Our Case Number: ACP-324410-26

Re: Proposed West Clare Railway Greenway Section 1: Kilrush to Kilkee Project
Kilrush to Kilkee via Moyasta, Co. Clare

Our Ref: P800107/2026

Proposed Development: West Clare Railway Greenway - Section 1 Kilrush to Kilkee
--

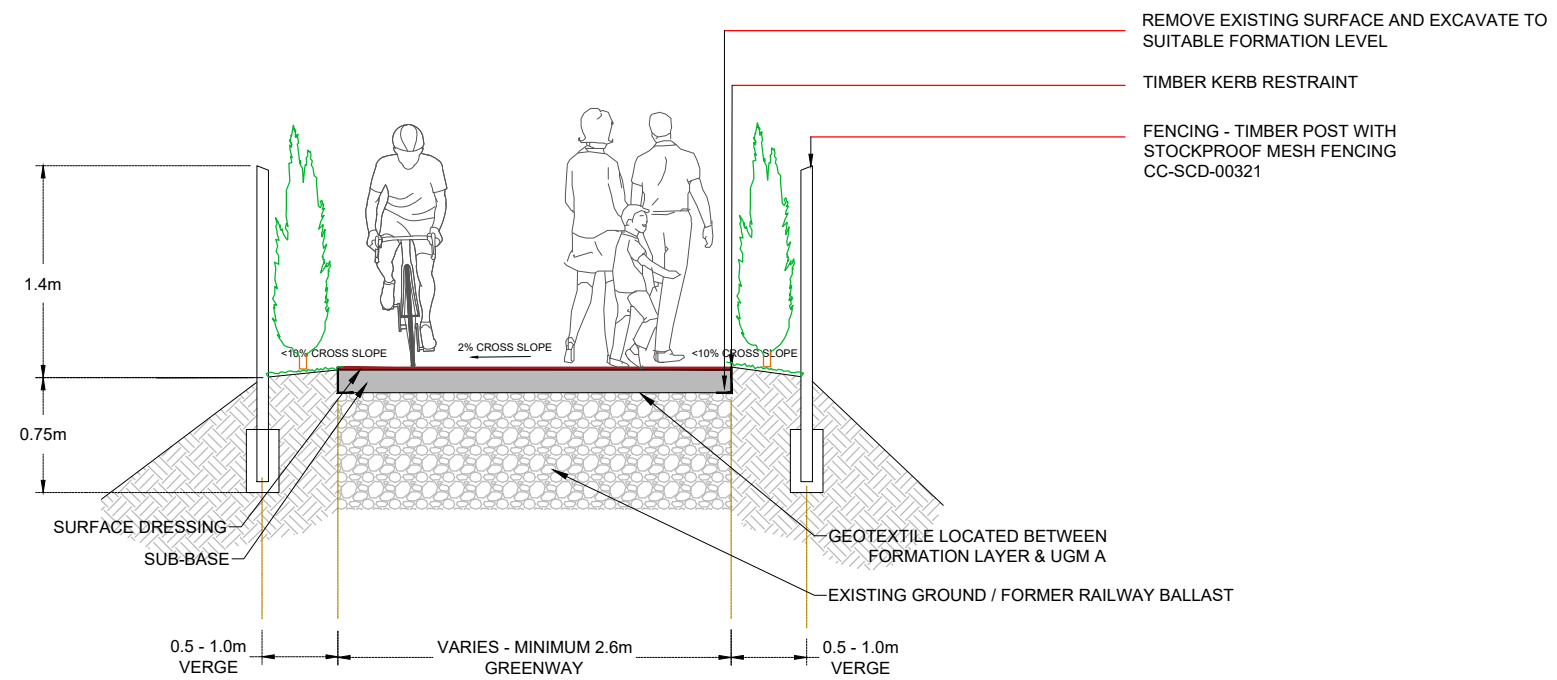
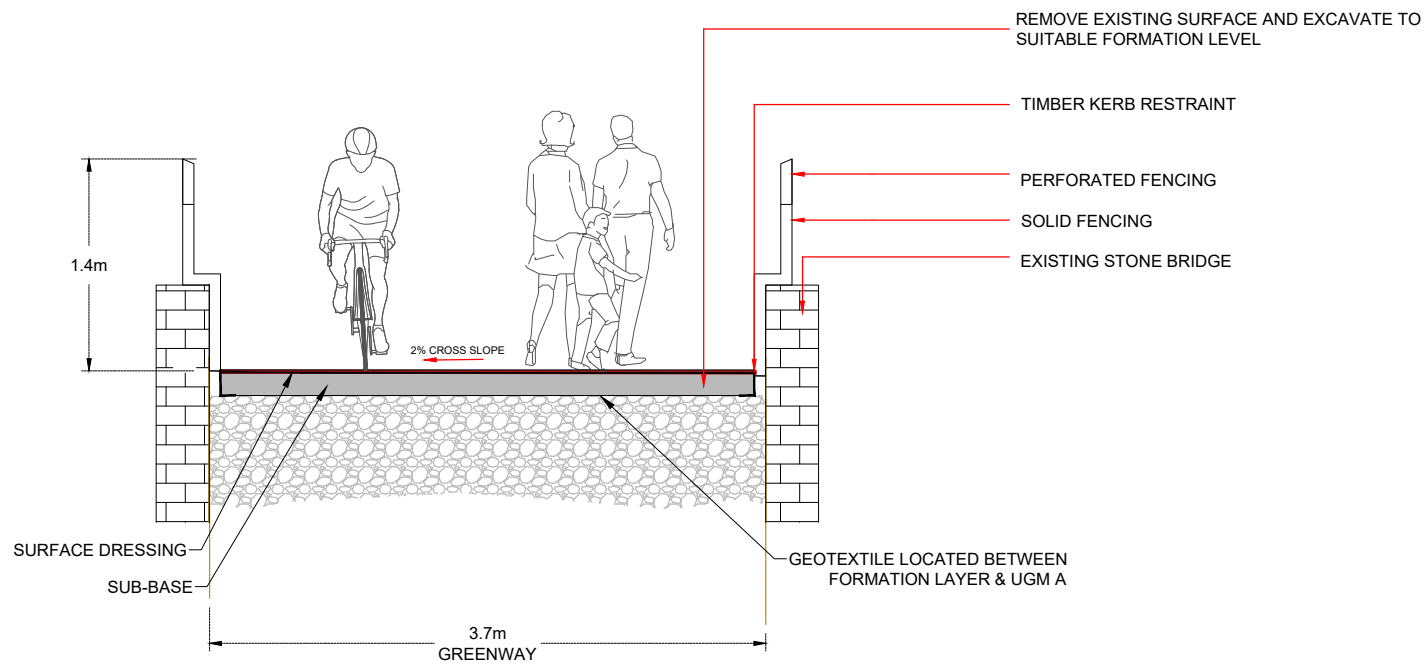
The Moyasta Bridge area is of particular concern due to its proximity to intertidal habitat.

- Proposed Development
- Sensitive Bird Areas
- Habitat Screening**
- Existing screening
- No Existing Screening
- Needs Vegetation
- Vegetation lost

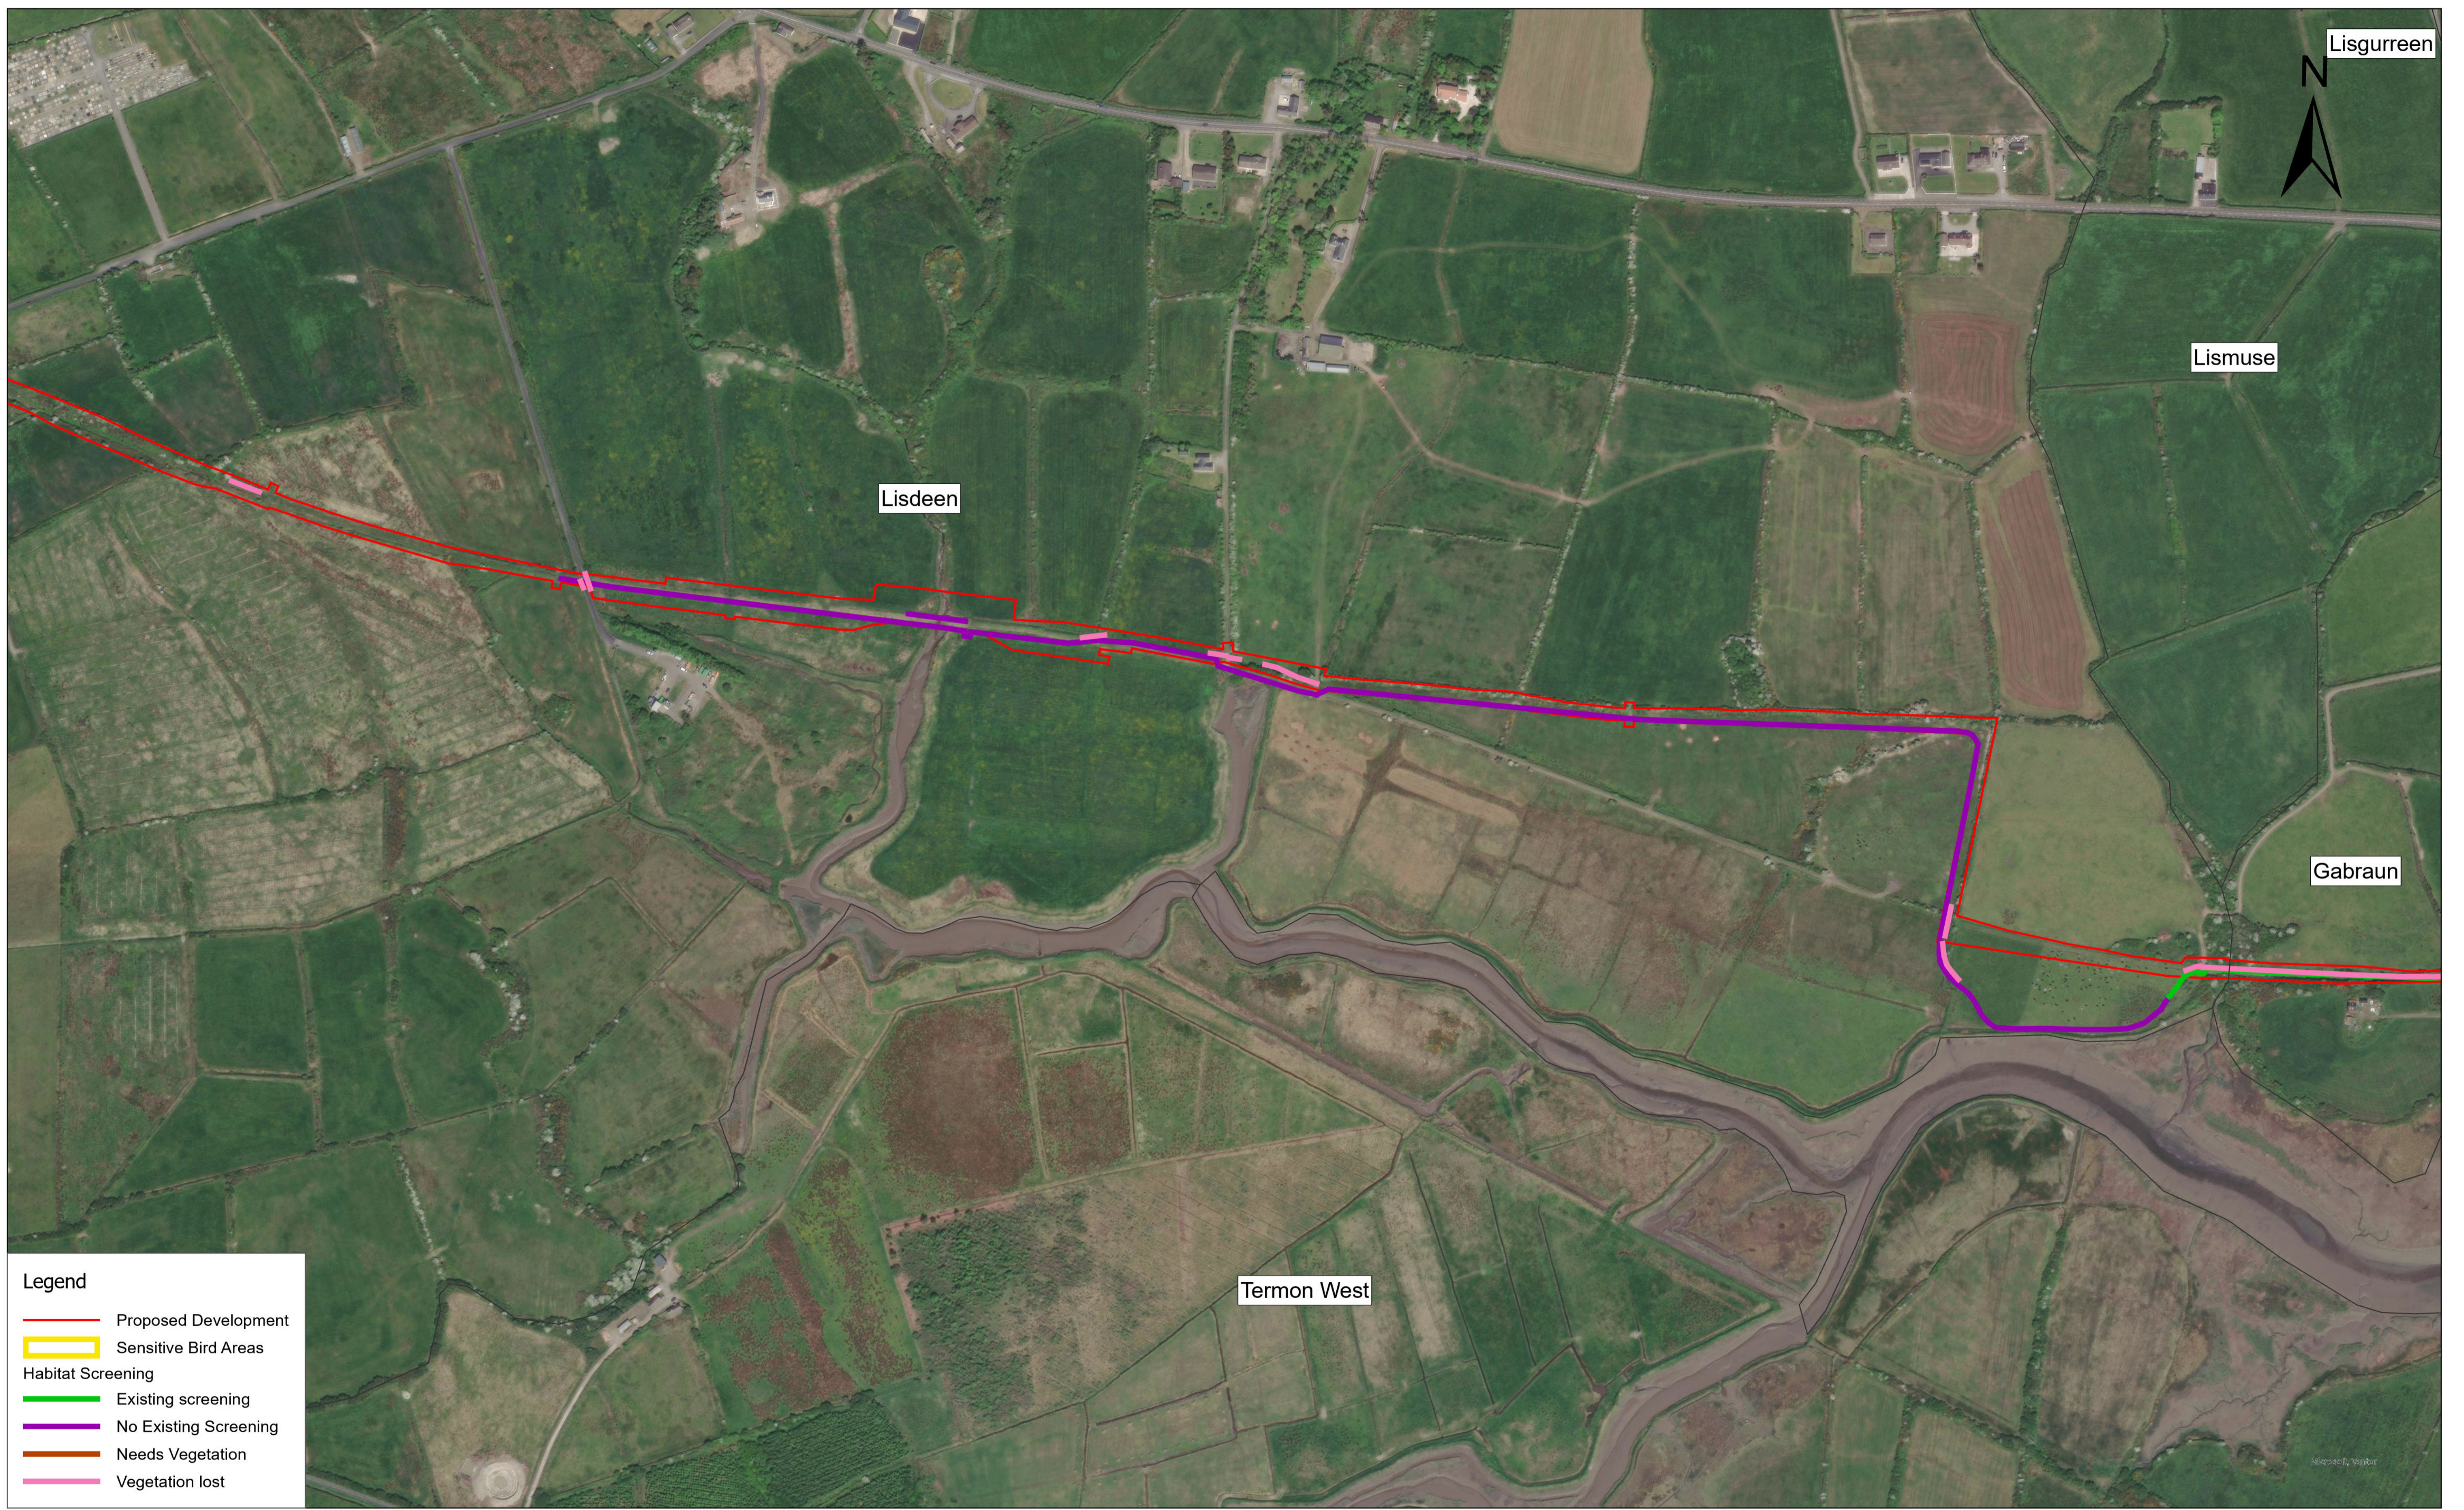
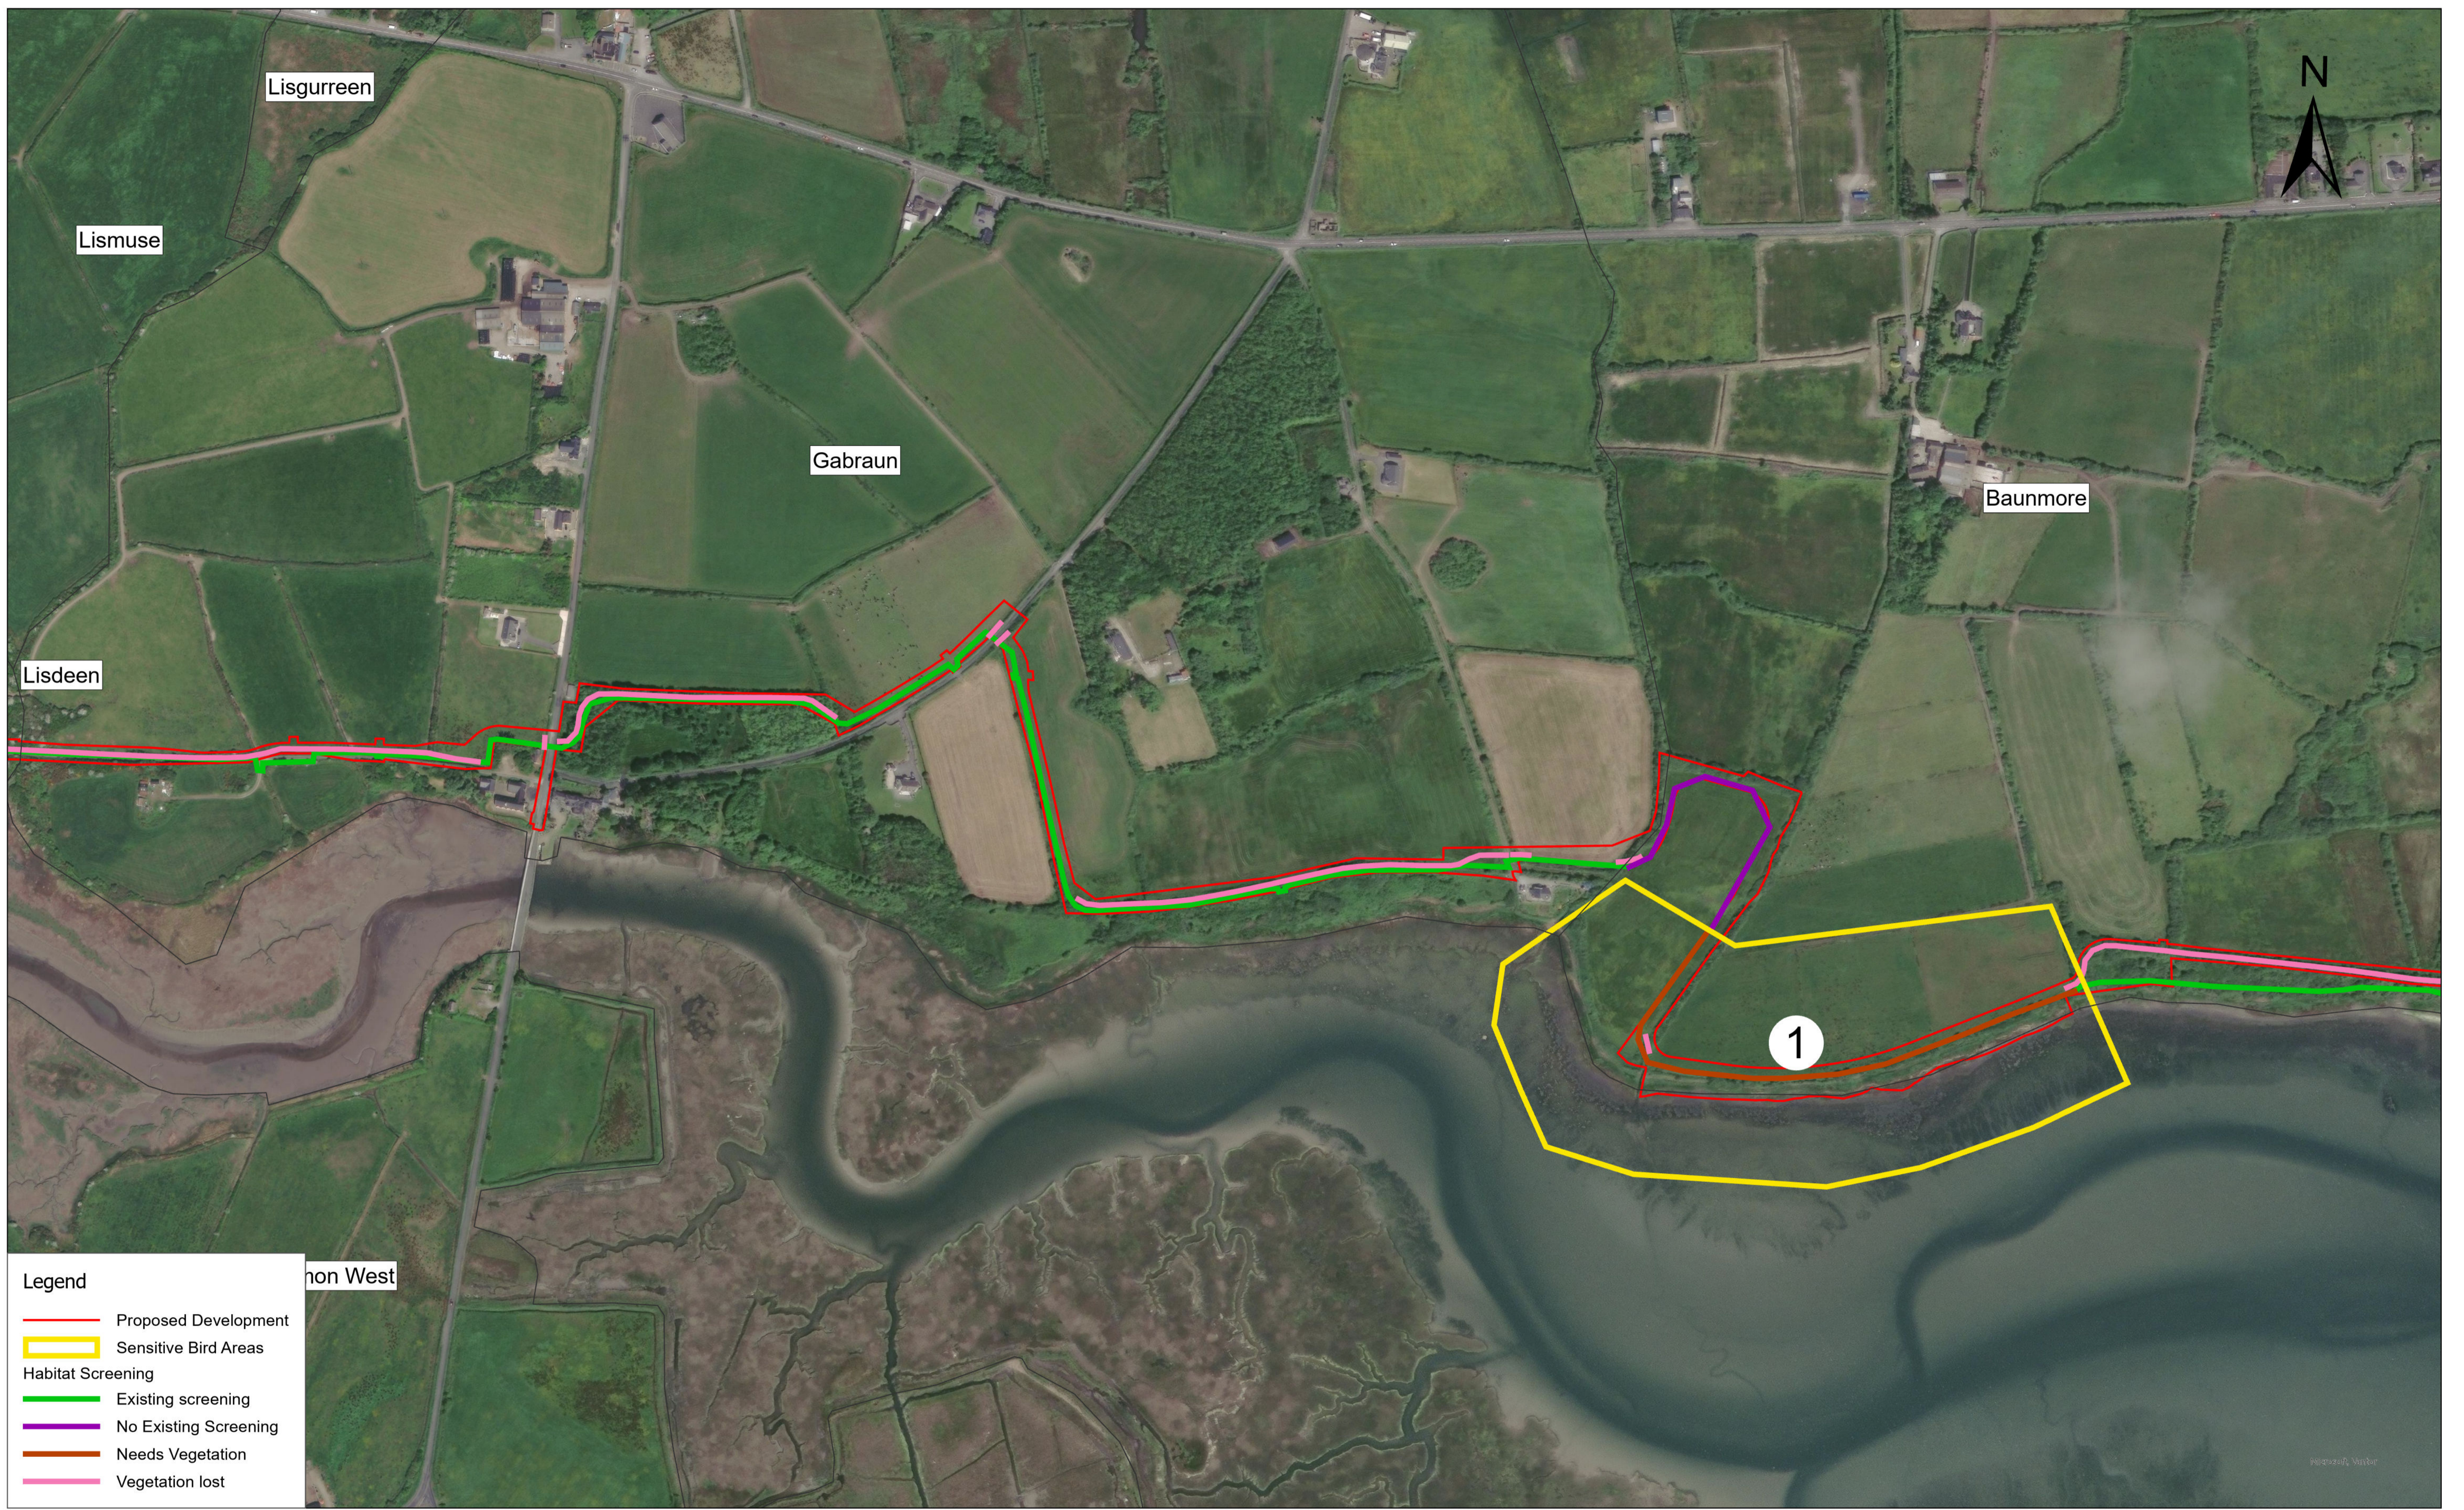
The proposal relies substantially on visual screening to reduce disturbance.

The Department welcomes the proposed screening and monitoring measures but notes that the NIS itself acknowledges that direct evidence demonstrating the effectiveness of screening in this context is limited.

Further information should therefore demonstrate how screening will work in practice and how its effectiveness will be monitored.

The design of screening and planting should avoid creating artificial predator perches overlooking important bird habitat.
